Your ref: 3/2016/0757

Date: 5th September 2016

**Planning Application 3/2016/0757: Discharge of conditions 5 (historic buildings assessment), 6 (bat survey mitigation) and 7 (greenhouse specification) of planning permission 3/2016/0108; The Dower House, Park Road, Gisburn BB7 4HT**

**PL01 (above) showing extent of section of wall to be removed.**

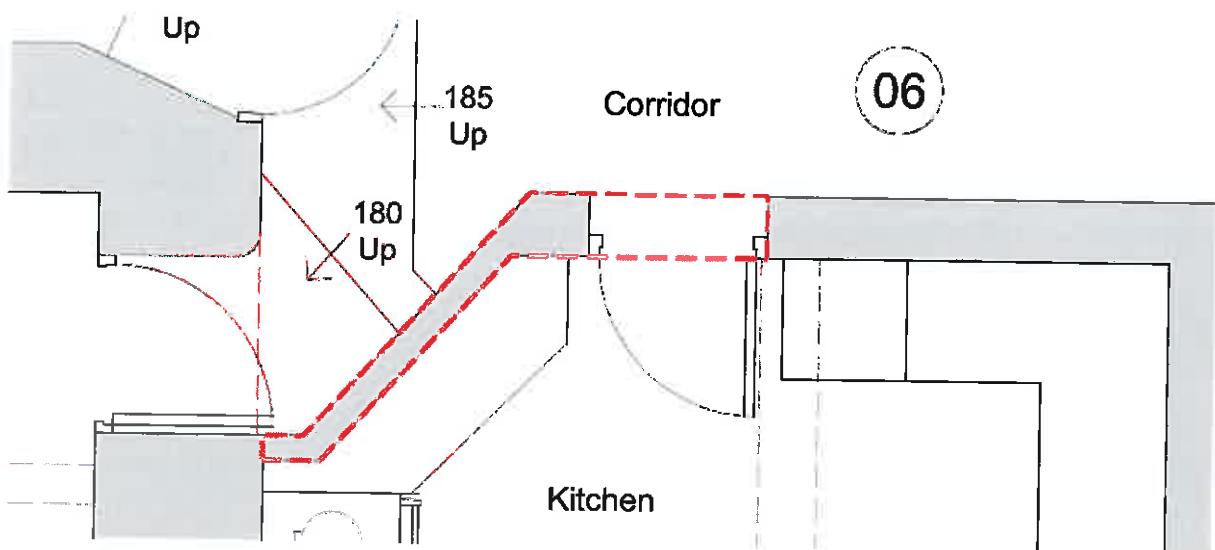
The above application is accompanied by a brief assessment of the historical significance of a short section of internal wall within The Dower House. We would agree with the conclusion that the section of wall is likely to be part of a later scheme of alteration and not original to the construction of the rooms now used as a kitchen and corridor. We would not object to the removal of the section of the wall as proposed, but would suggest that its construction method and materials are documented photographically as part of the removal process.
